Appeal Decision

Decision date: 07 September 2015

Appeal Ref: APP/A2525/W/15/3033451

The Barn, West Drove North, Gedney Hill, Spalding, Lincs PE12 0PL

Drawing No.
02B

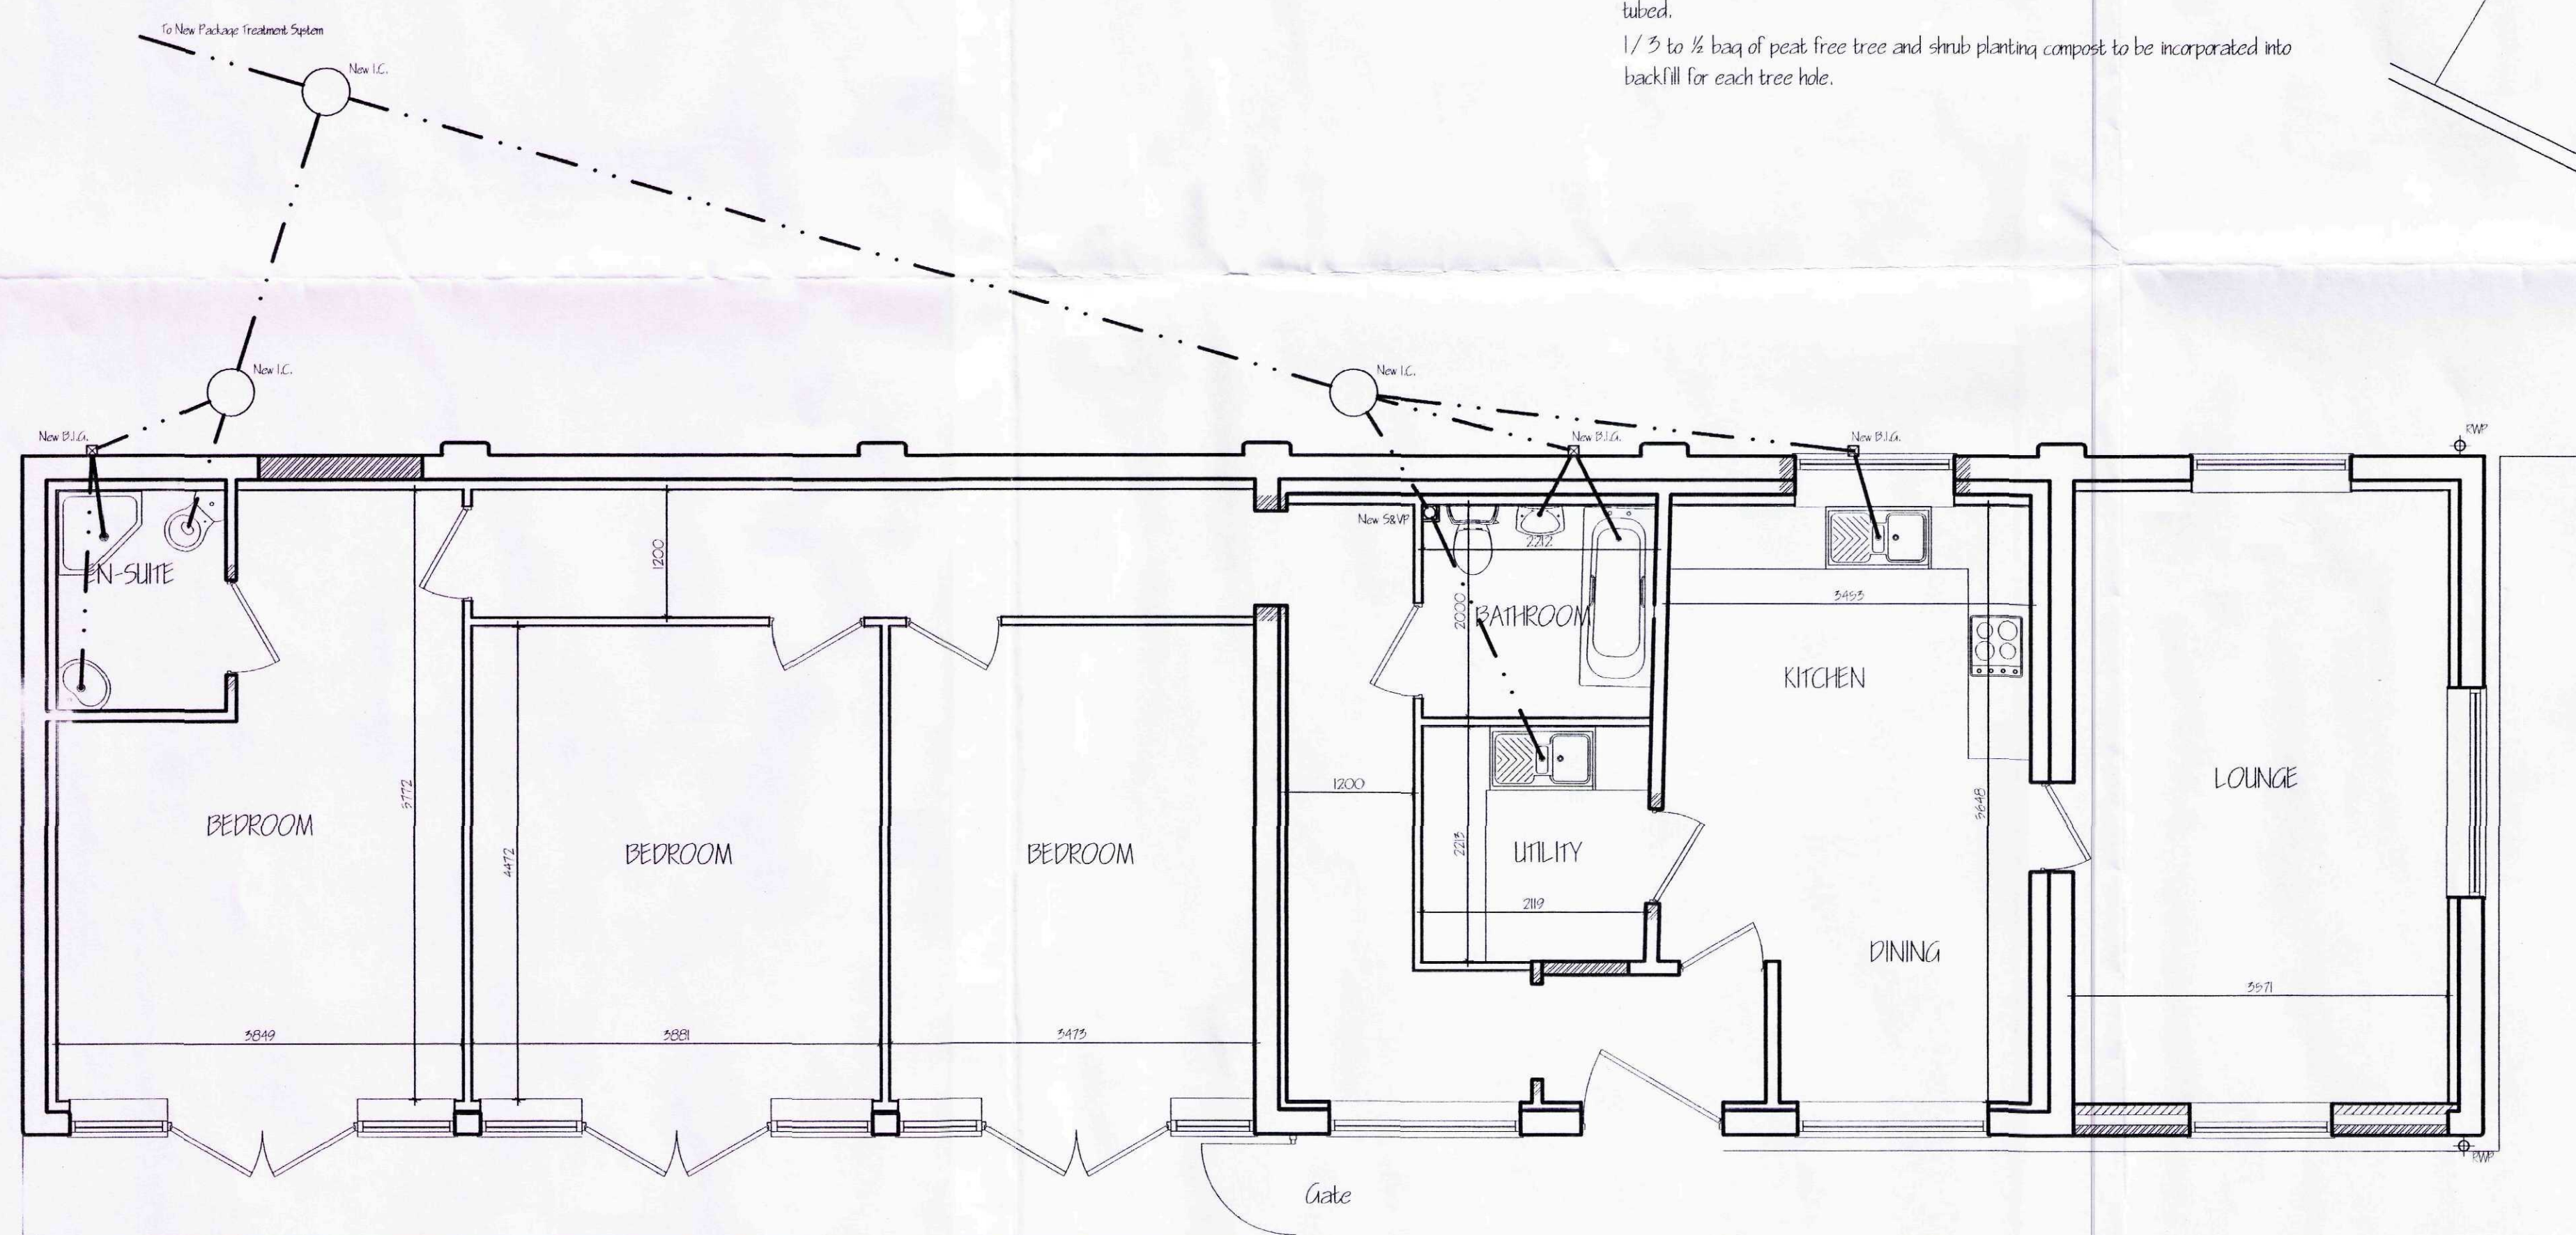
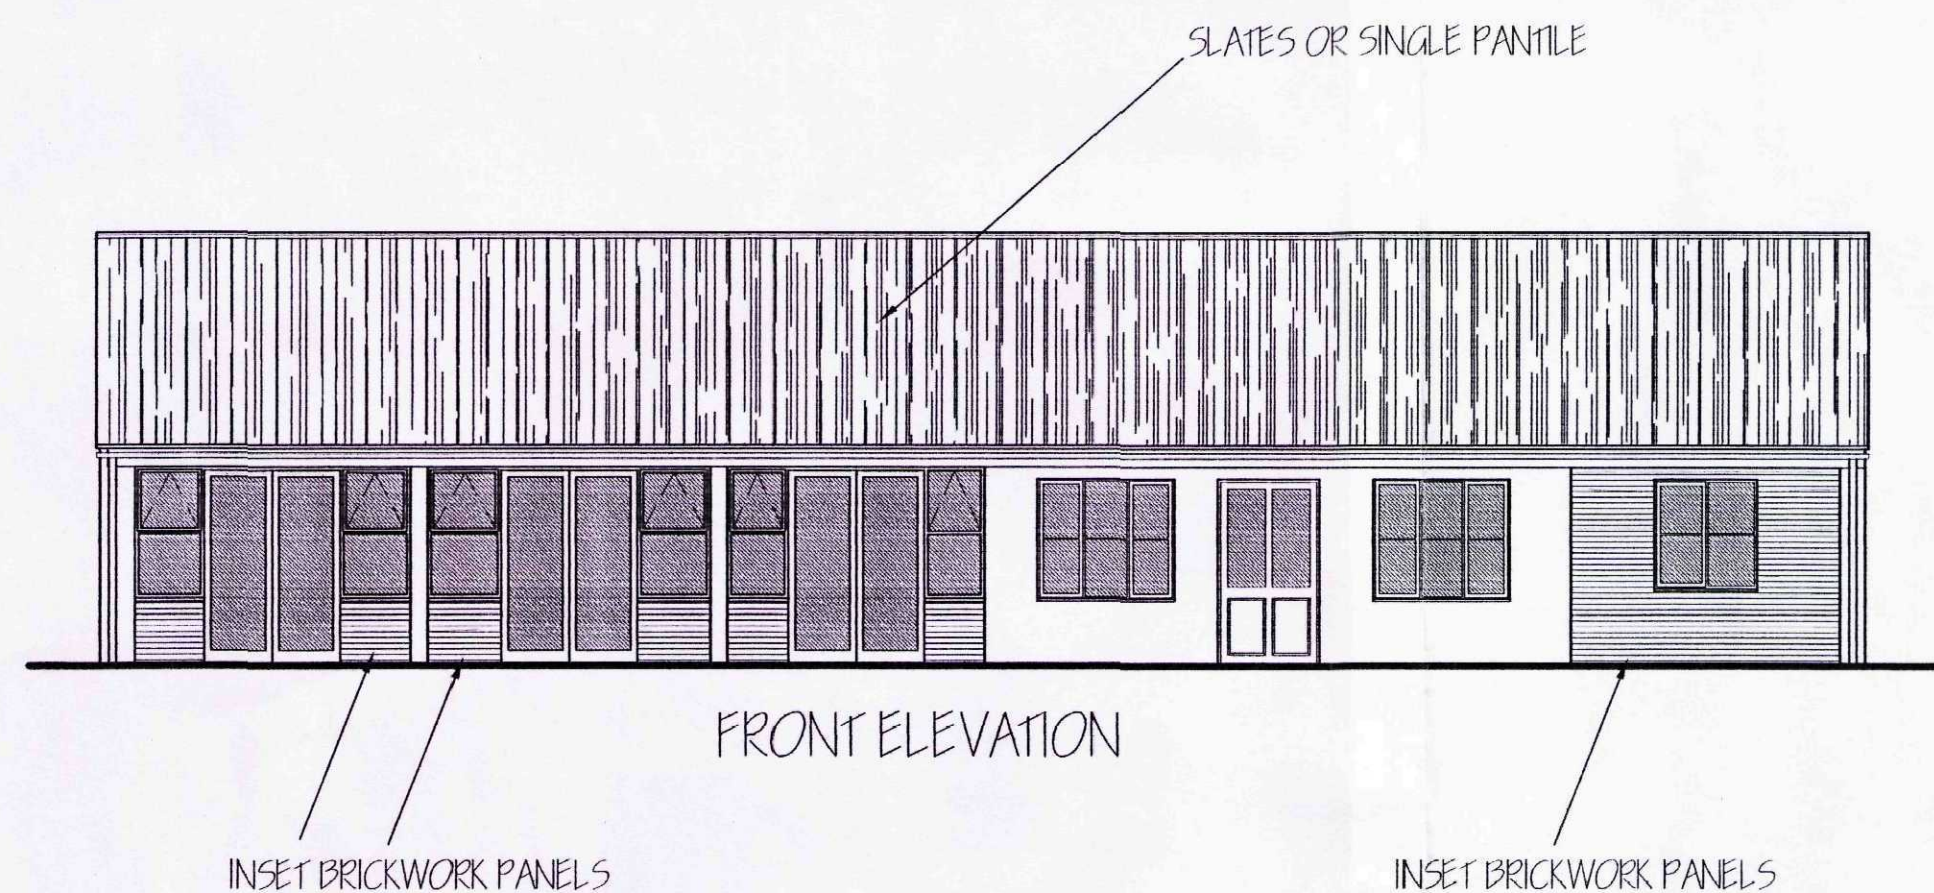
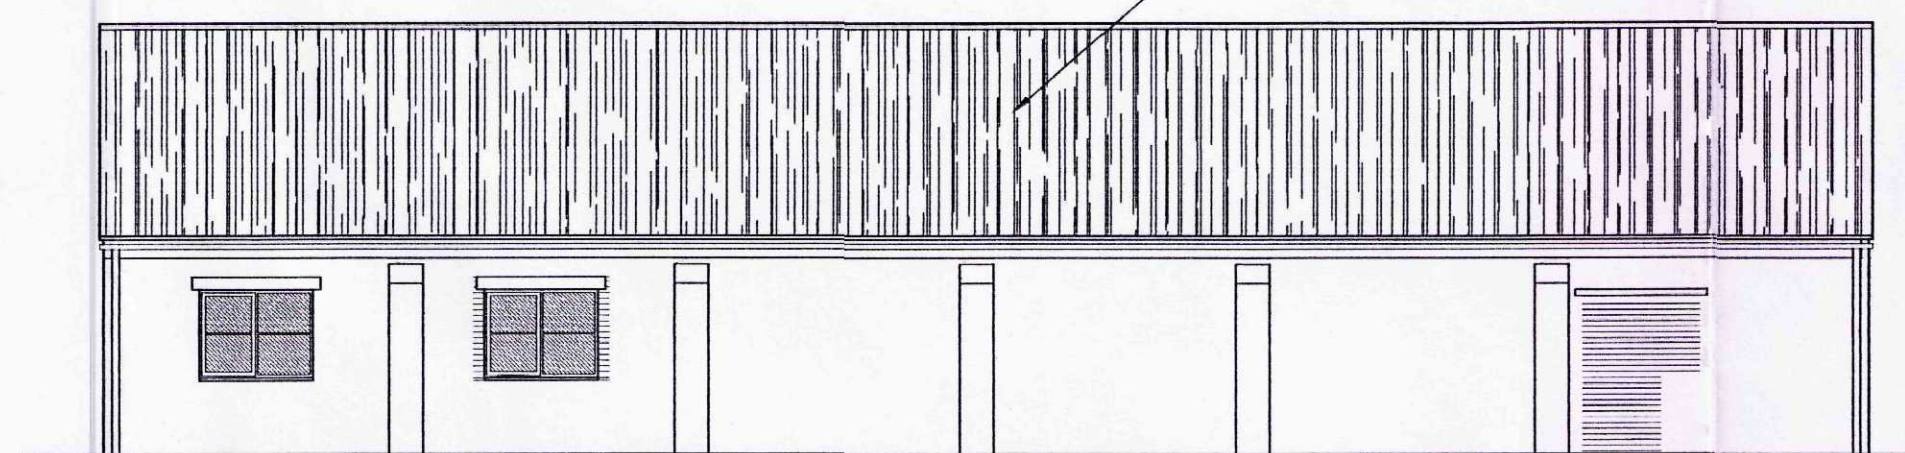
8. Notwithstanding the existing plans that show timber supports and a partial roof, to the west of the main building, there is now no roof and only two walls remaining which are leaning away from each other. The proposed plans indicate that a roof and a number of windows and walls are proposed on the west elevation and these would require significant new external supports to accommodate the load in this part of the development. Accordingly, I find the degree of new structural elements that would be required to take the loading which would come with the external works necessary to provide for residential use would fall outside the scope of the provisions of Q.1(i) and on this basis, the proposal would not be permitted by Class Q.
